Date: 06 December 2021

**APPLICATION BY HIGHWAYS ENGLAND FOR THE A47/A11 THICKTHORN
JUNCTION PROJECT.**

**DEADLINE 4 SUBMISSION: COMMENTS ON DOCUMENT 6.3 ENVIRONMENTAL
STATEMENT APPENDIX 13.1 – FLOOD RISK ASSESSMENT REV 1**

Figure C-16: Flood depth difference presented as magnitude of change criteria in Table 3.71 of DMRB LA113 for the 100-year event with 35% climate change

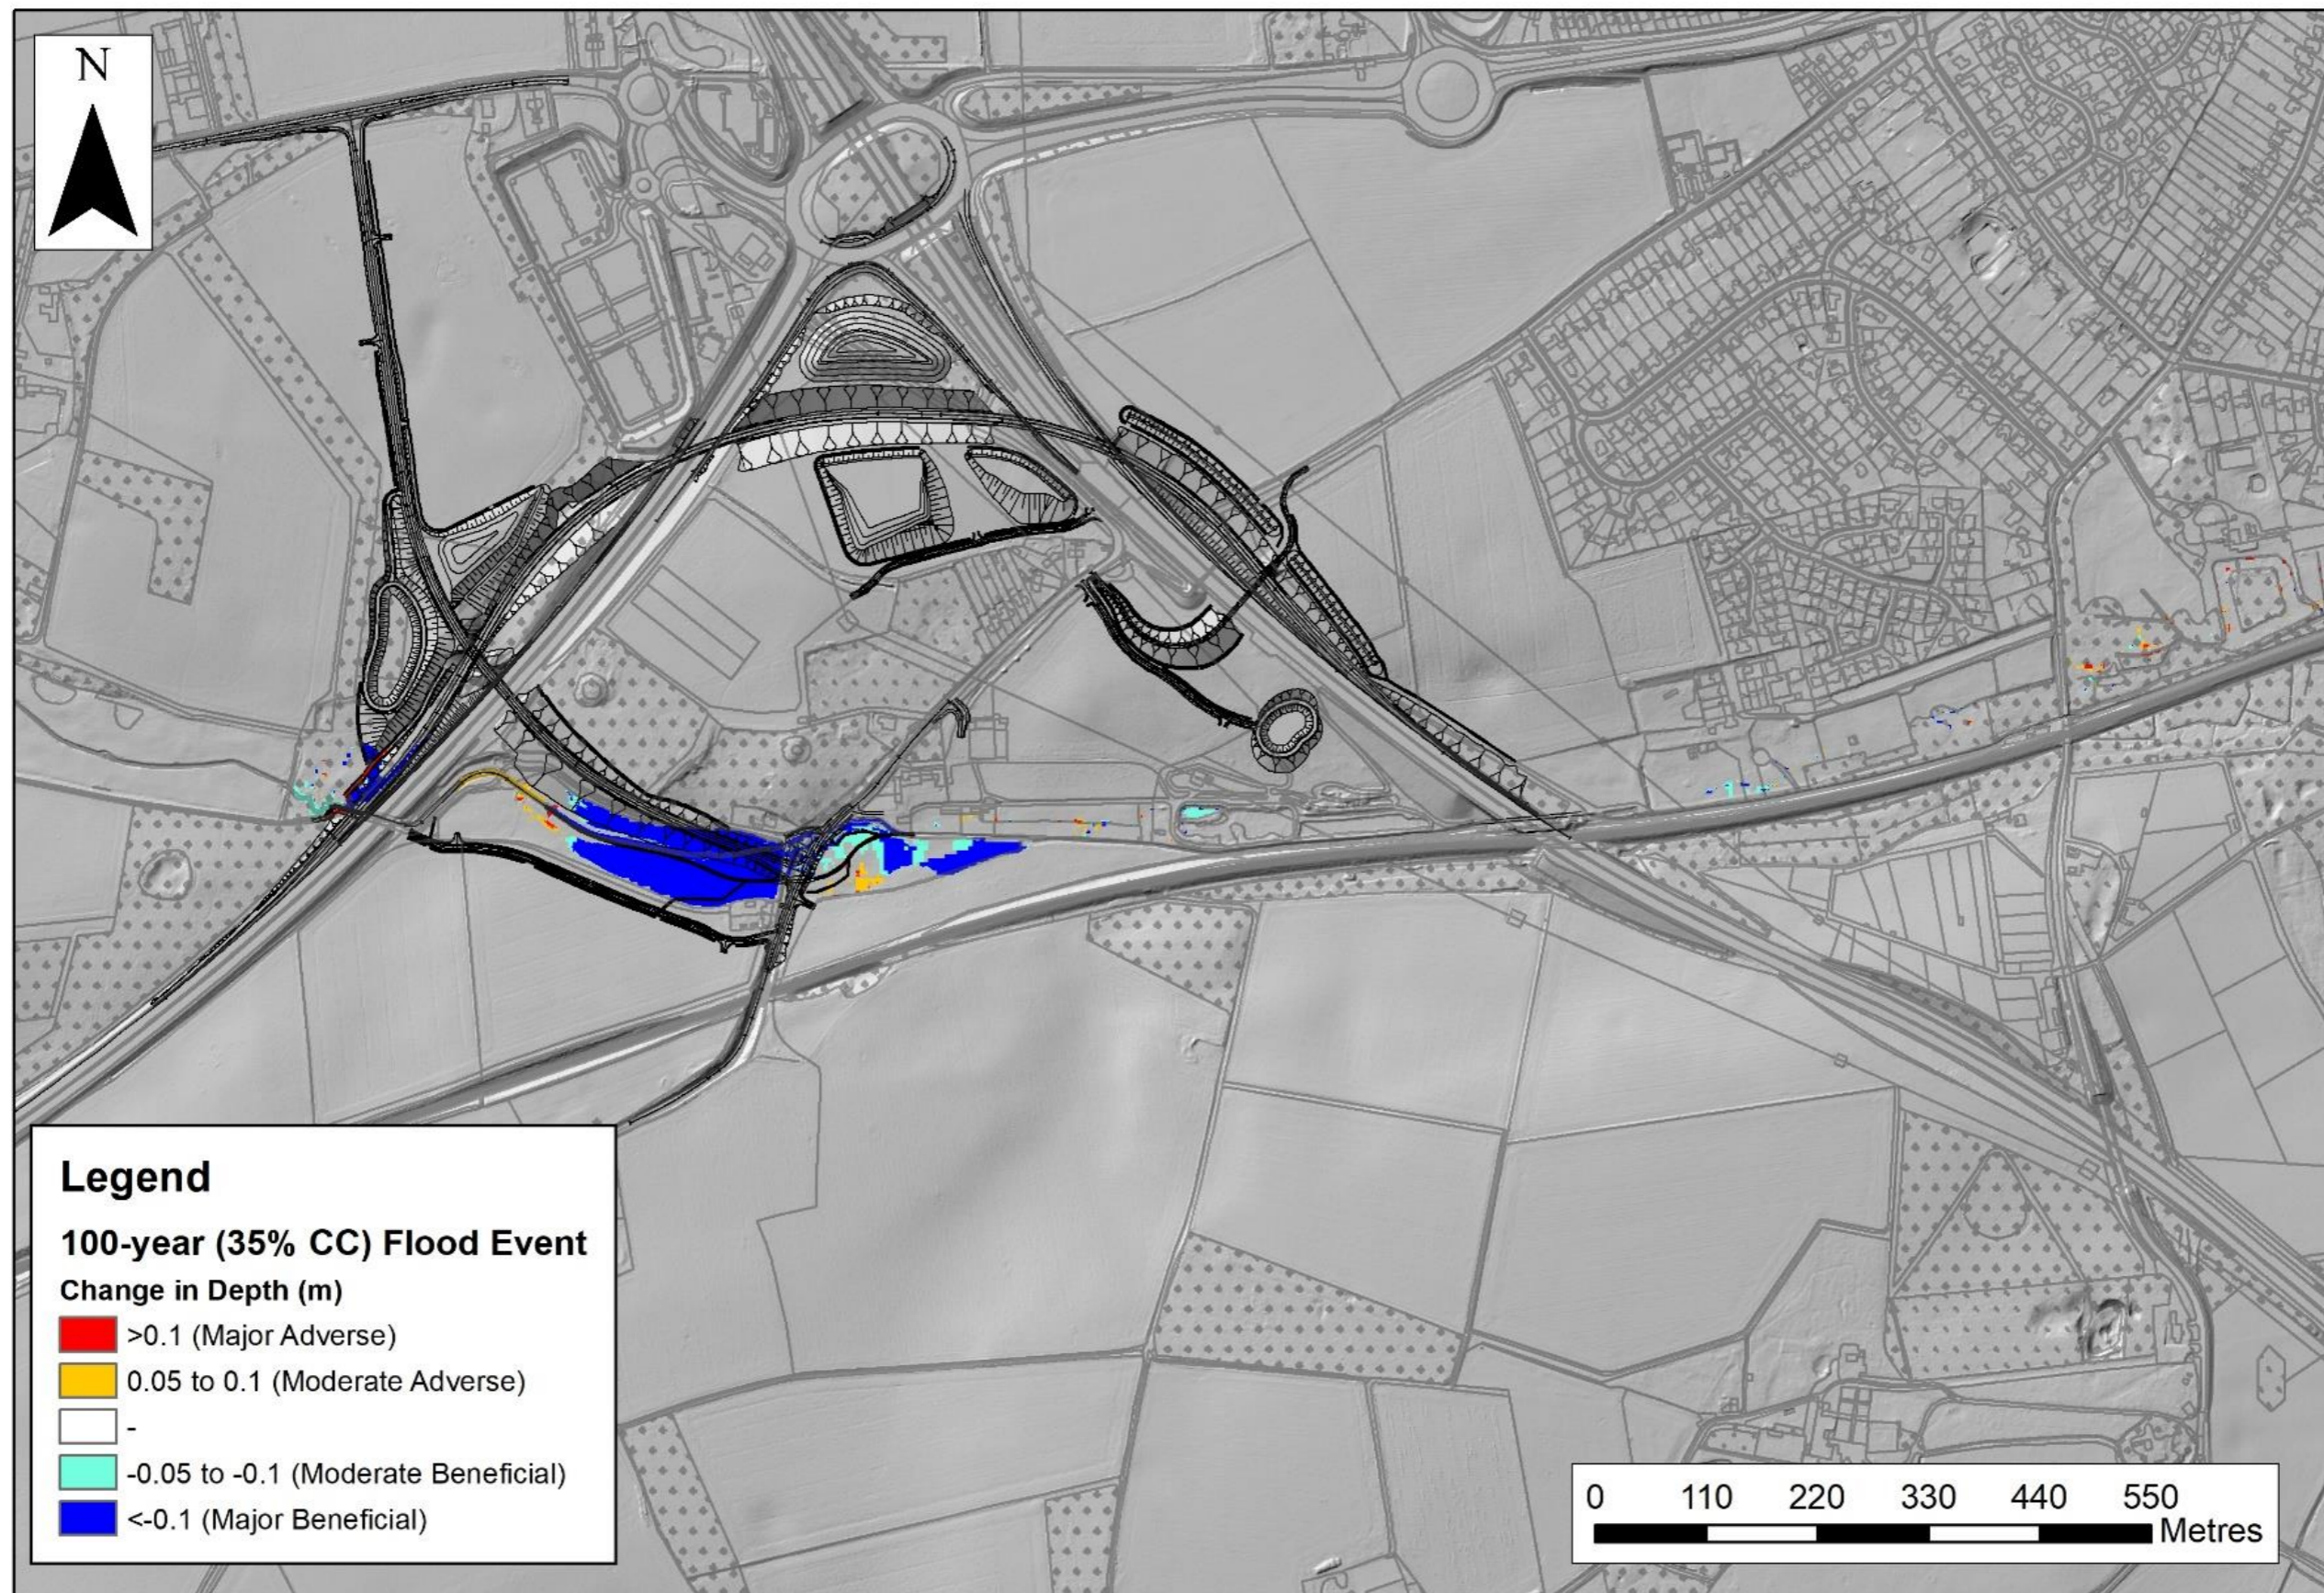
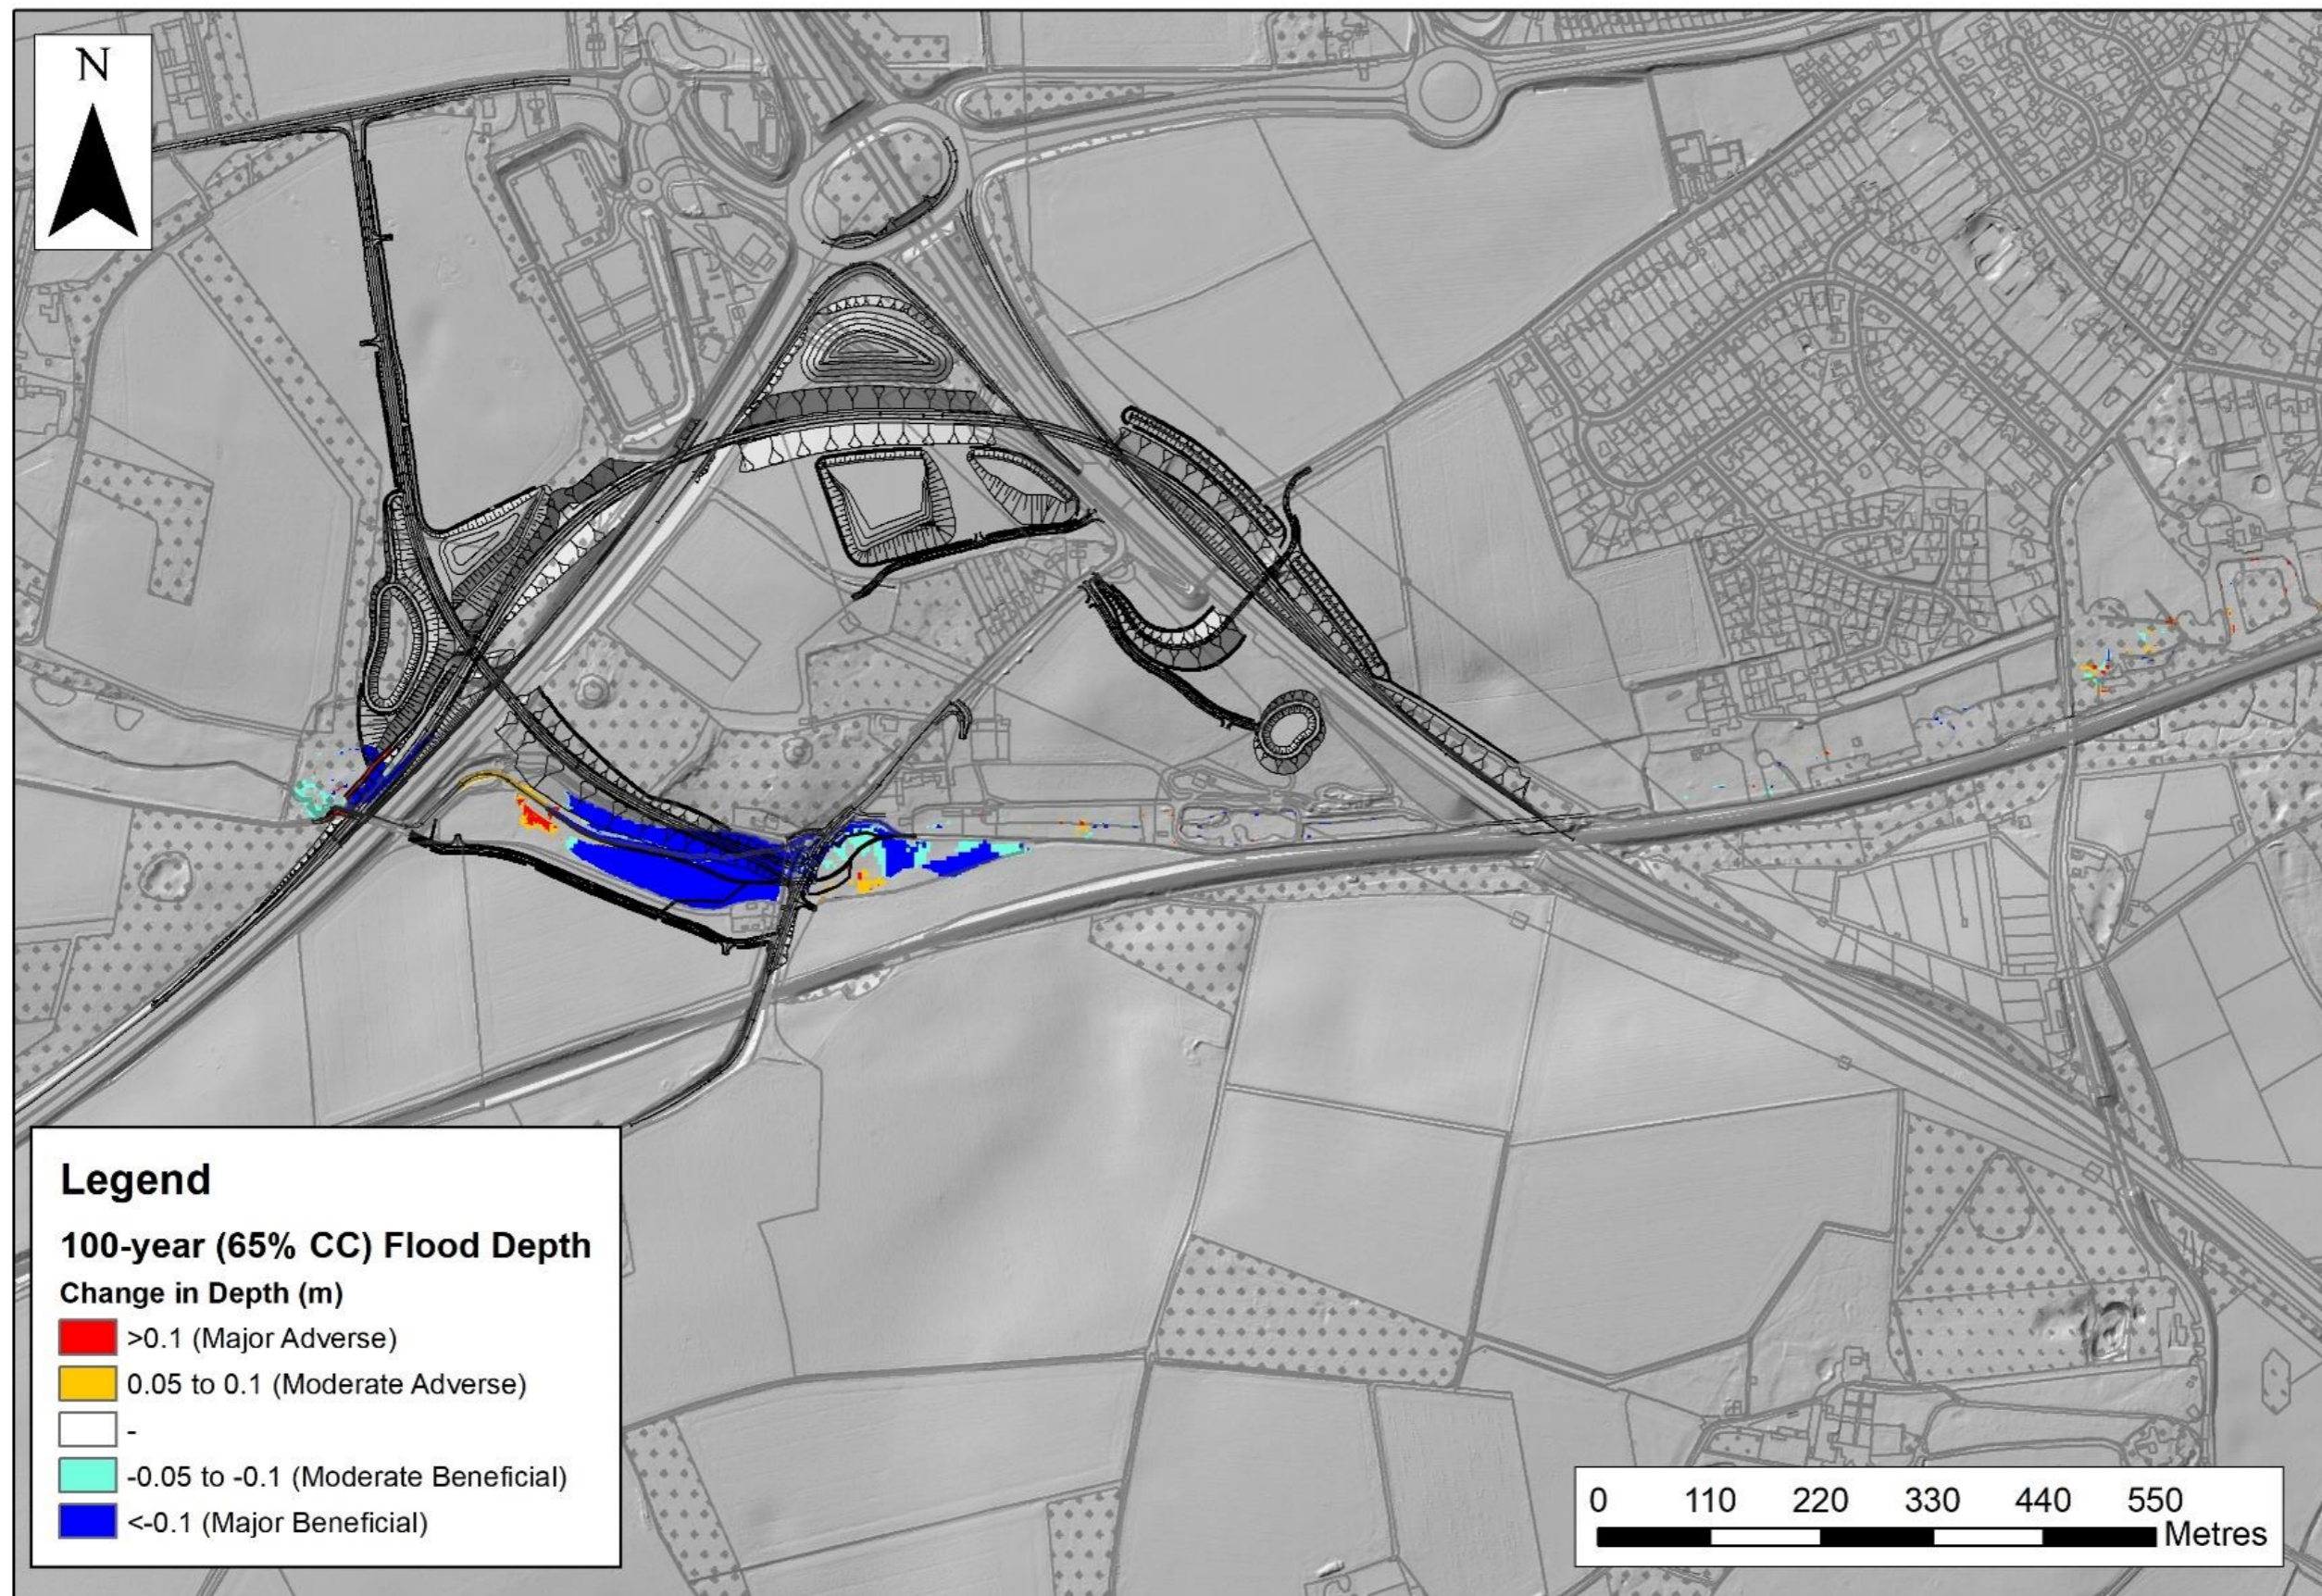
Paragraph 8.2.11 has also been reworded and additional figures C-16 and C-17 have been provided in Appendix C (Flood depth difference maps). We note that there are localised areas where flood depths are either increased or decreased to a major or moderate magnitude. The FRA states that this is a result of the “removal of

the culvert throttle, stream realignment, extension to the A11 culvert and alteration to a farm access track”.

Paragraph 8.2.11 then states that the localised areas that are impacted are agricultural land and amenity areas, which are classed as ‘less vulnerable’ and ‘water compatible’ under the NPPF flood risk vulnerability classification.

This section then goes on to state “No ‘more vulnerable’ receptors, as defined under the NPPF flood risk vulnerability classification, are predicted to be adversely affected. As such the Proposed Scheme would not result in significant adverse impacts on flood risk and compensatory storage would not be required”.

The Environment Agency agree that the localised nature of these adverse impacts and the receptors impacted, mean that in this instance compensatory storage should not be required. We do suggest that if any of the adverse localised impacts are on third parties land that the Applicant engages with the affected land owners.
